Reference: SF18/41152

**COMPLIANCE WITH CONSENT CONDITIONS
SSD 7484, The Sandstone Precinct**

- **Condition B44 B:** Schedule(s) of internal and external conservation works relating to significant heritage fabric both the Department of Lands Building (SHR00744) and Department of Education Building (SHR00726)
- **Condition B7A:** Nibs in Function Room 7 & 8
- **Condition B6:** Plans demonstrating that the Education Building entrance foyer design has been modified to retain/reuse a greater portion of identified significant fabric of the stone surrounds to the lifts.

SHEET (2)

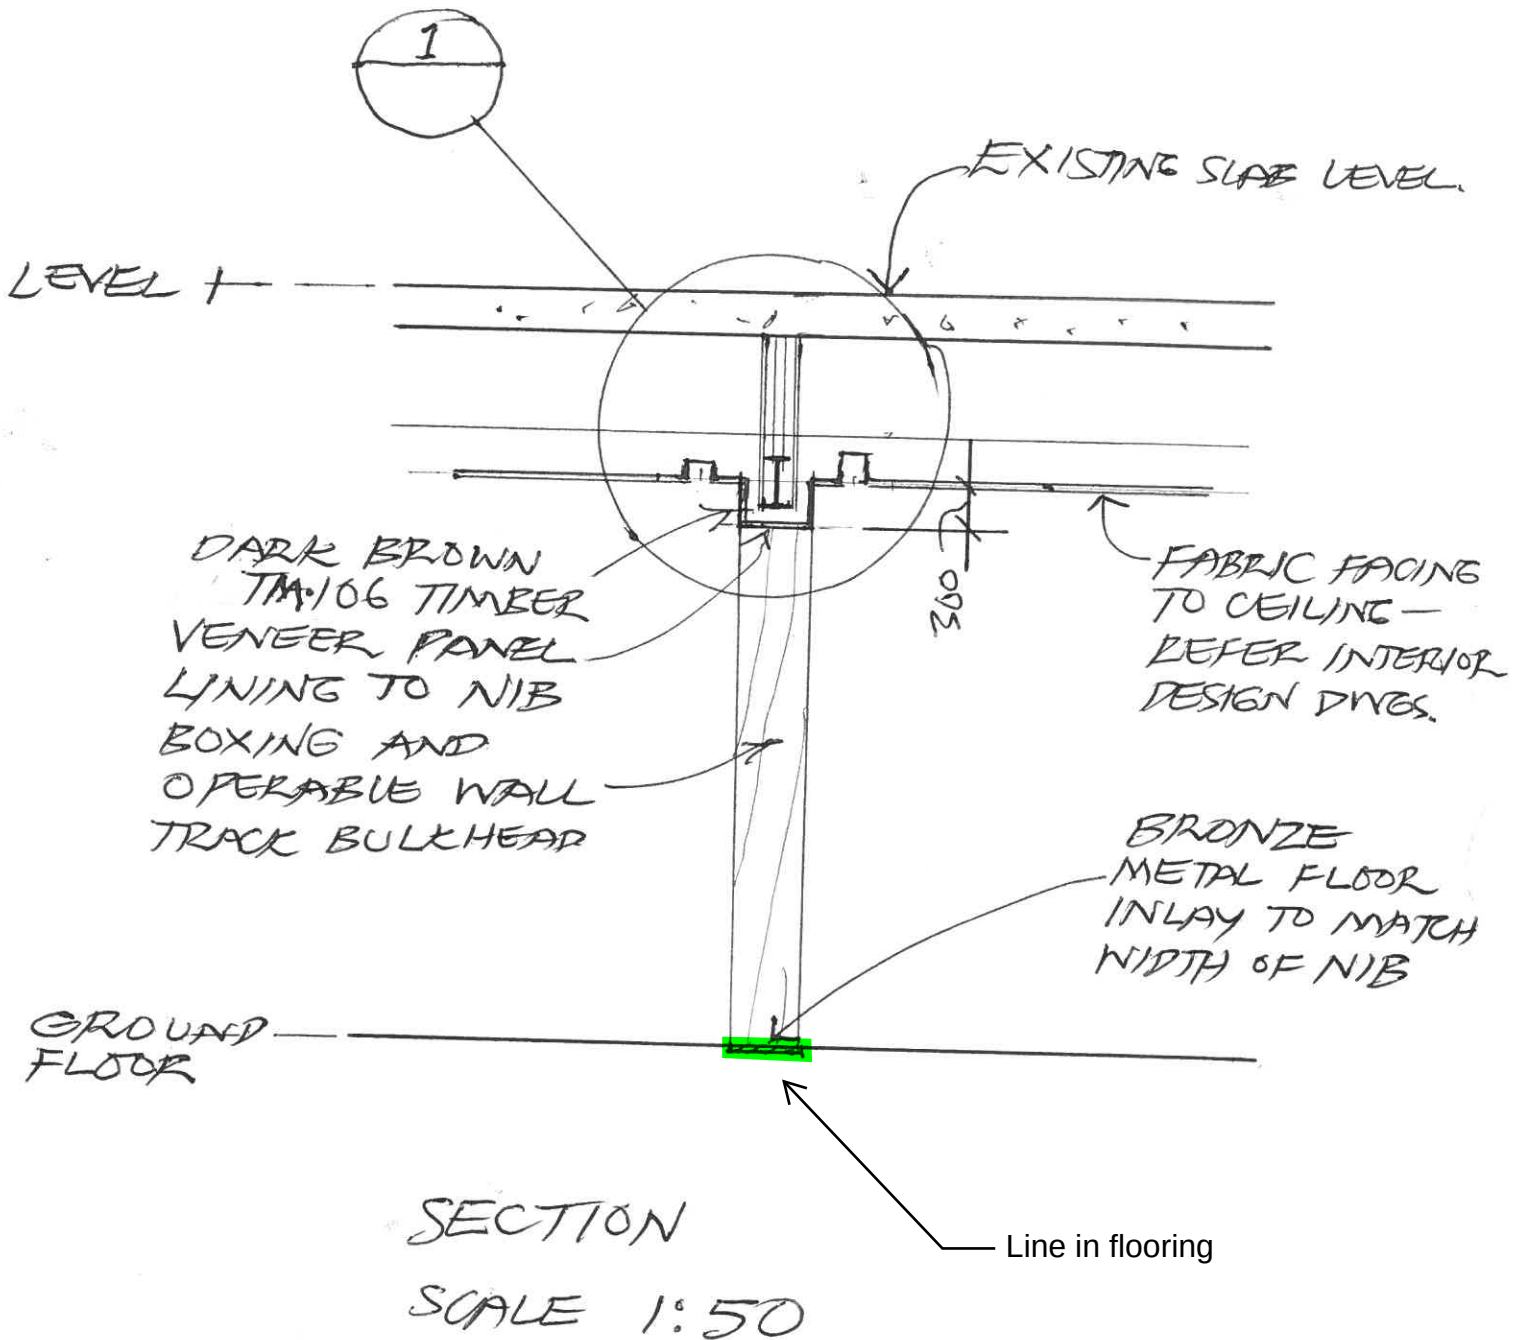
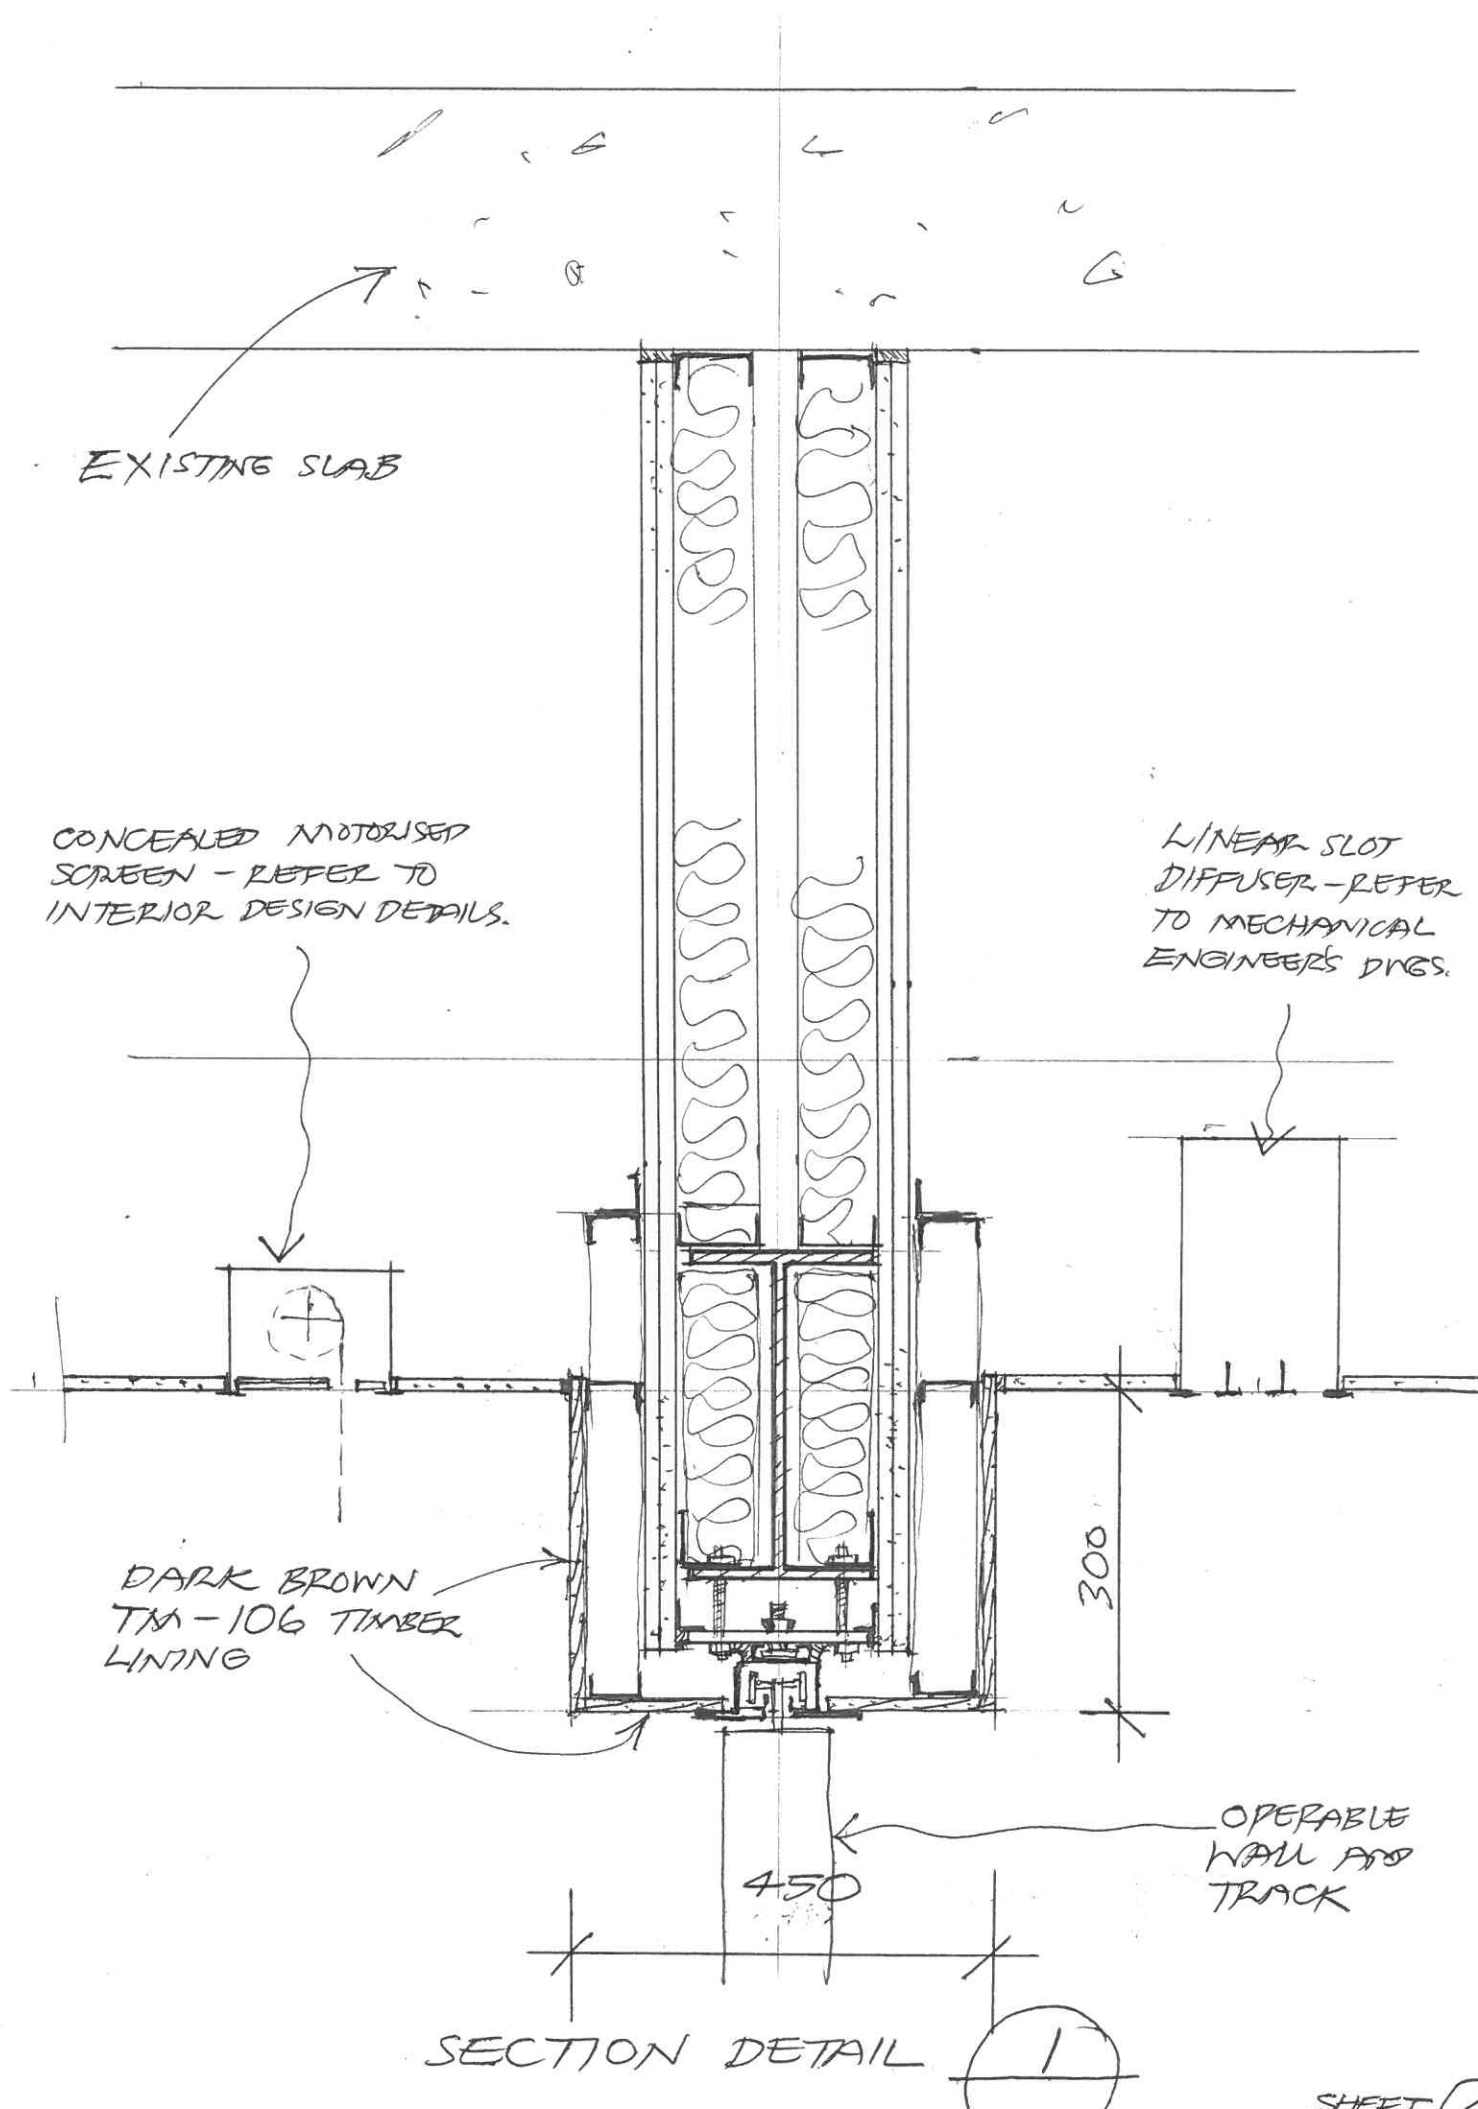
e) Prior to issue of Construction Certificate 3 – Foundations/ in ground structure (CC3), amended plans are required showing detailed design of the opening between function rooms 7 and 8. The plans are to show the retention of substantial wall nibs and head, and a line in the flooring to interpret the original wall configuration, prepared in consultation with the project heritage consultant, Heritage Council and Council, and submitted to the satisfaction of the Planning Secretary.

As delegate of the Heritage Council of NSW, I confirm that this information sufficiently addresses the requirements of the conditions and will satisfactorily fulfil the Condition of Consent for 'The Sandstone Precinct' SSD 7484 when implemented as described with the oversight of the nominated Heritage Advisor:
